RE: SUB19-002/SEP19-005 – Proposed Preliminary Plat  
2825 W. Mercer Way, APN 2174502425  
Request for Additional Information, Third Review

The City of Mercer Island Community Planning & Development Department has completed a third review of the application materials associated with SUB19-002/SEP19-005 for compliance with the Mercer Island City Code (MICC) for the above preliminary long subdivision application. All comments must be addressed prior to issuing the staff report and scheduling the public hearing.

10/12/22
 JOB NUMBER:
13-118
 SHEET NAME:
RS-01
 SHT **6** OF **9**

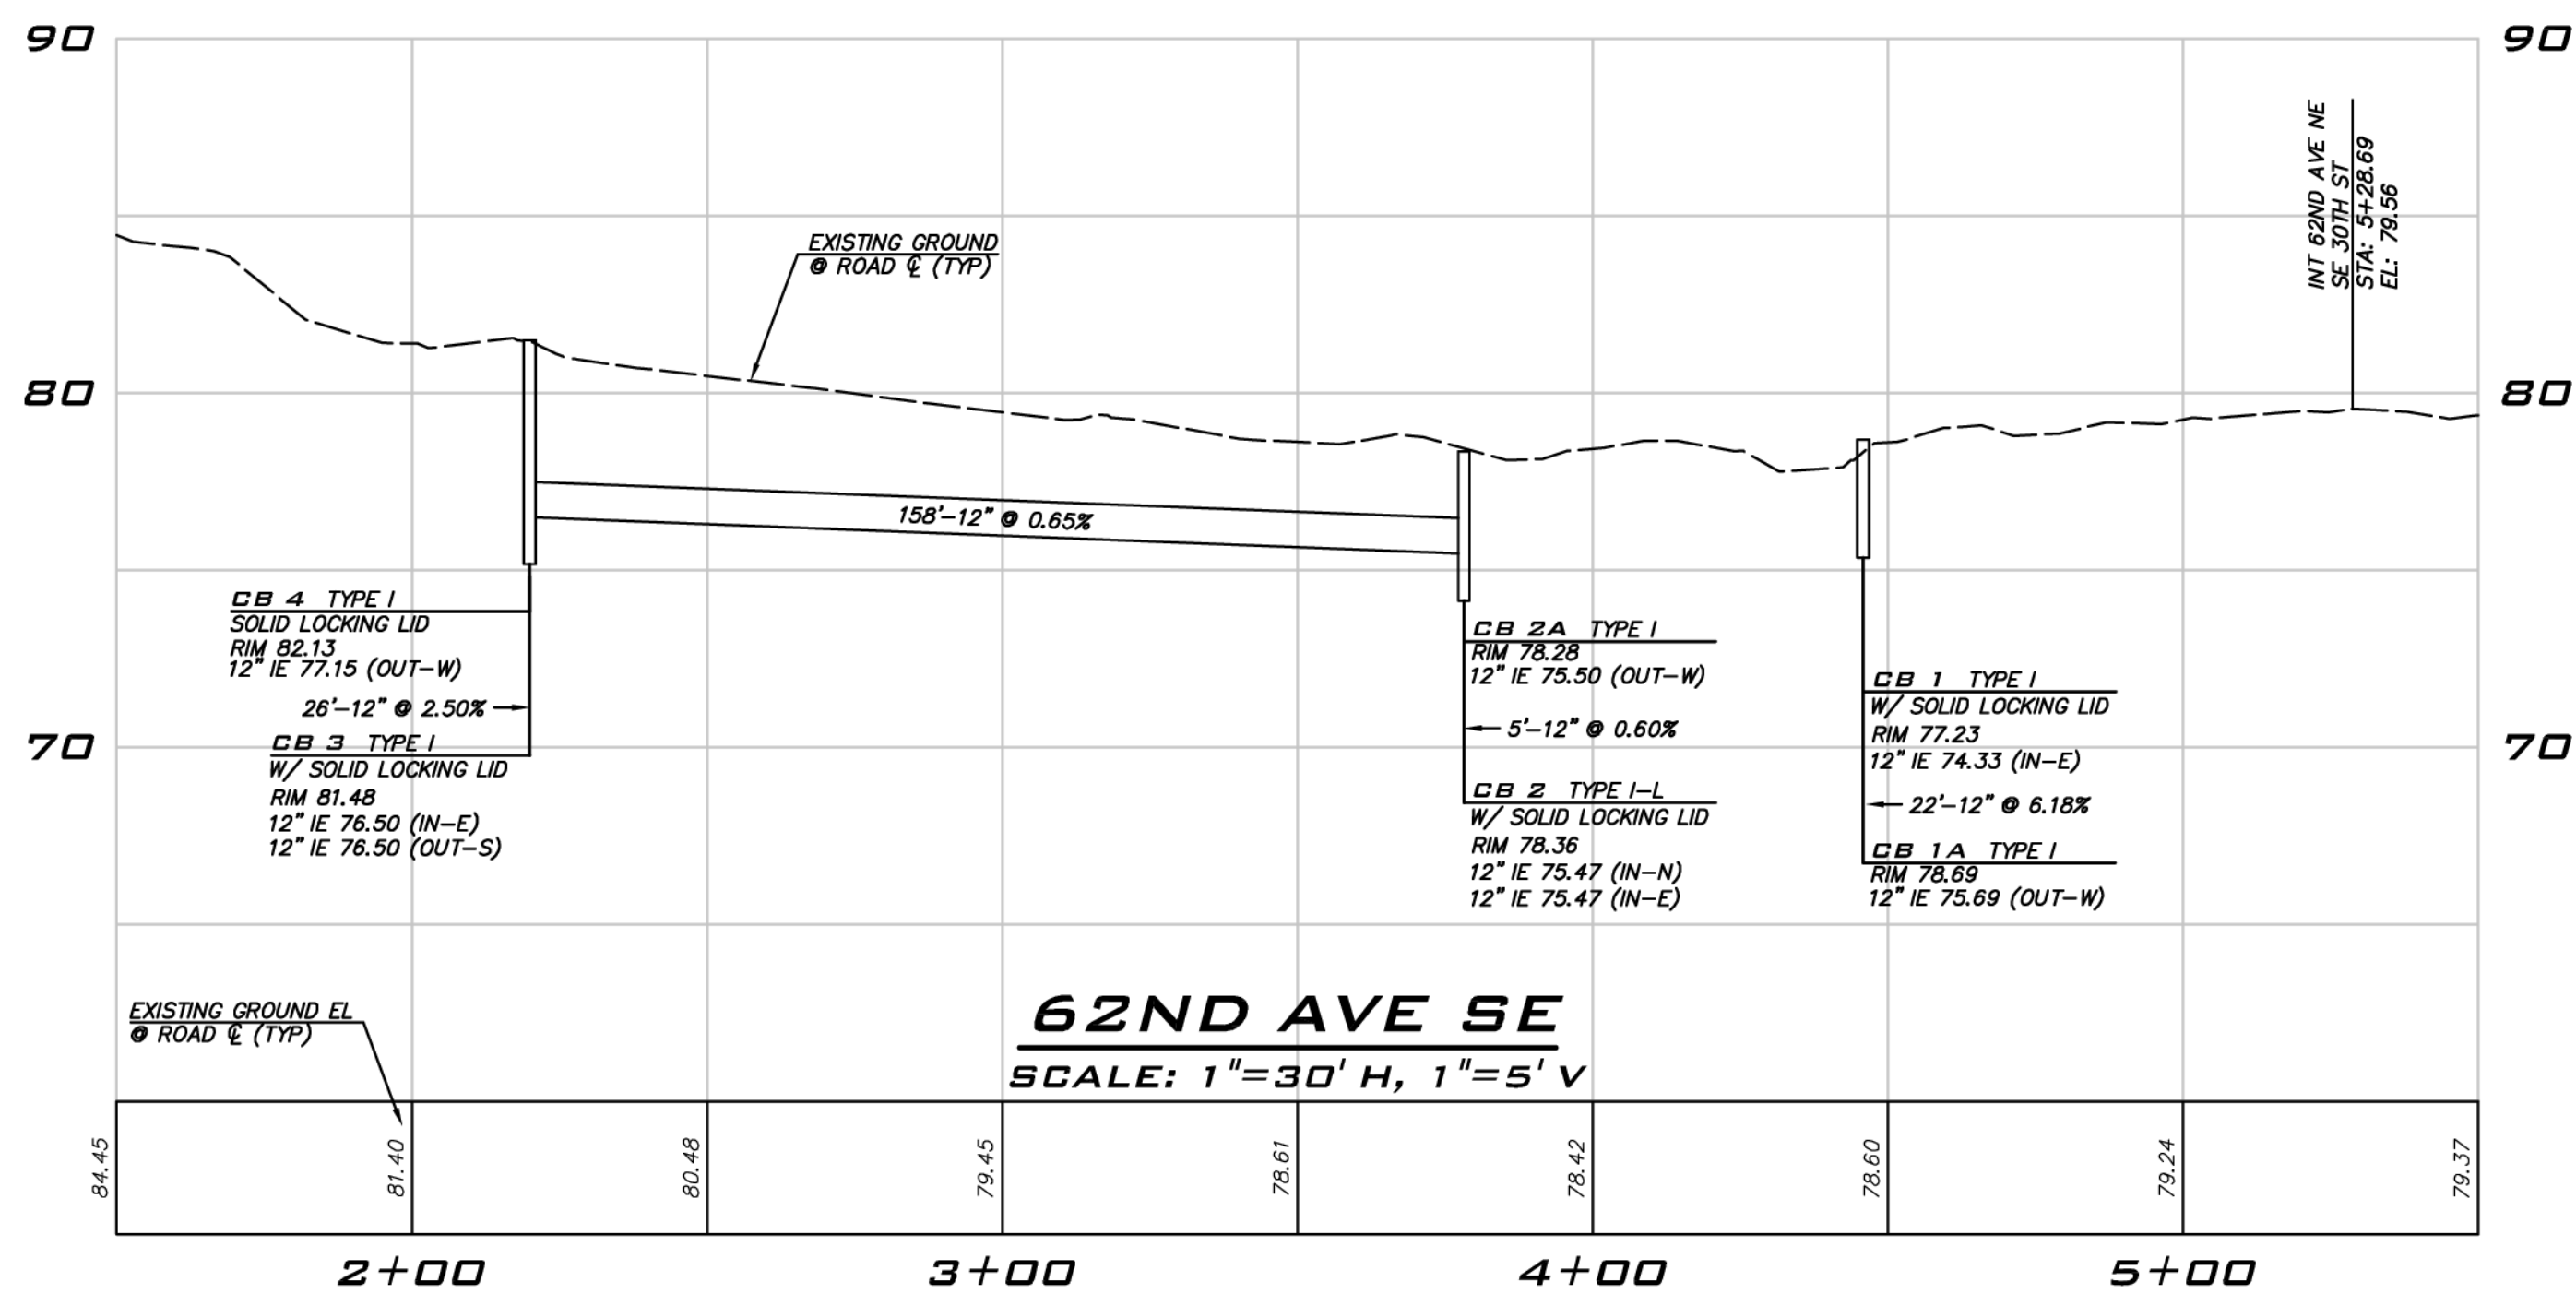
Applicant must identify turn around area on plat map and provide a plan on how this area will be maintained for fire access only and not parked vehicles. Examples would be painted lines (maintenance agreement) and/o signage.

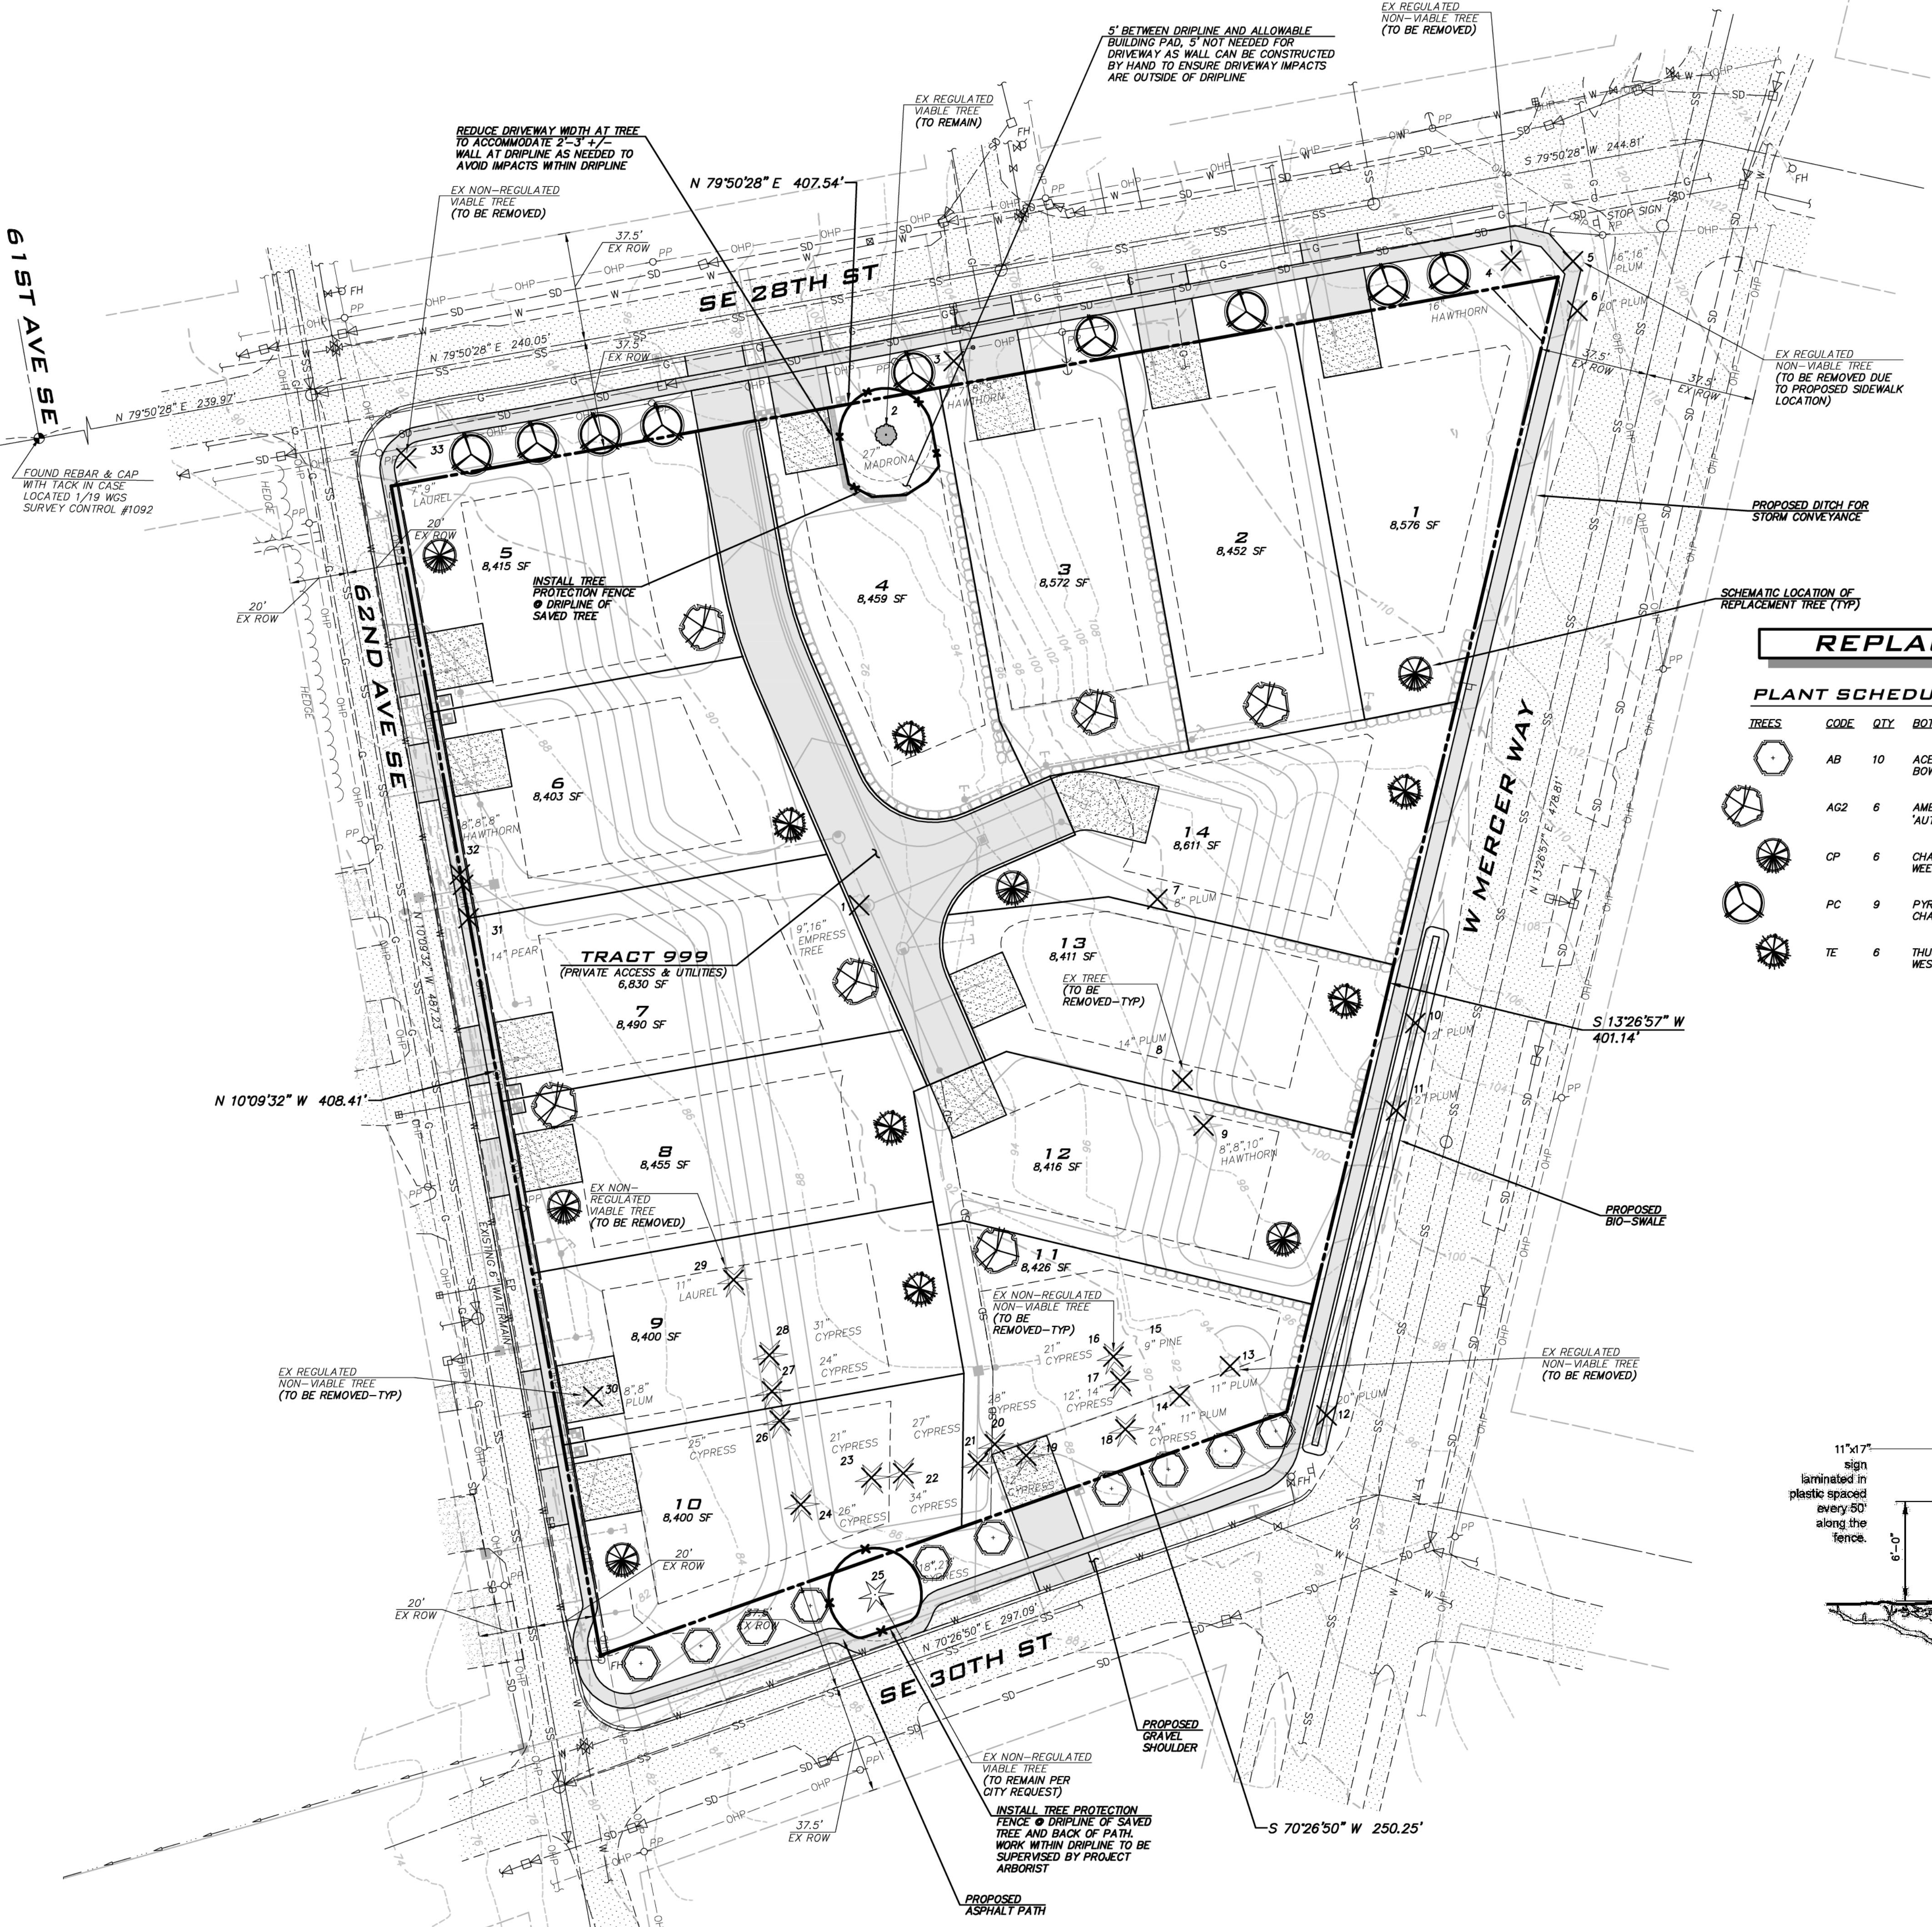
1. Second repeat correction. A new wall not shown in Sub 1 looks to be within the tree protection zone. The construction of the wall as shown would encroach into the tree 2's protection zone. Place this wall with enough room to construct without encroaching into the tree protection zone. As suggested in a Planning comment a longer driveway would resolve this issue. The building pad, driveway, grading and wall to be shown outside that limit with enough space to reasonably construct building. This means showing at least 5' of space between building pad and driveway in addition to the 16' of protection. SUB3 still shows the retaining wall right against/within the tree protection. This could not be built without taking the tree protection down and encroaching into tree 2's limits of allowable disturbance. A call out states 5 feet between the tree protection and wall and building pad. But this is not clearly shown. Show building pad and wall with this clearance. Move both the building pad and the wall to keep the 16-foot tree protection zone from the face of the tree to the chain link fence.

1. A replanting plan is required at the time of building permit review. At least half of the trees need to be Pacific Northwest native. The trees need to be at least 10' apart from each other, structures, fences and utilities. If you can show no room exists on site for all the required trees, the remainder

can be a fee in lieu if requested. Update the replanting plan to show trees on city property moved onto the property line so they will be shared trees. Confirm they are at least 10' away from any existing/new utilities. The pear and red maple on the property line will be replaced with the following species that are less invasive/overplanted. Plant Regal Prince® Ware's Oak (*Quercus x warei* 'Long') or similar approved equal on SE 30<sup>th</sup> instead of the pear. Replace Bowhall maple with *Acer rubrum* 'Frank jr' Redpointe maple or similar approved equal on SE 28<sup>th</sup> st. A tree watering plan must also be submitted to ensure the trees survive long term.
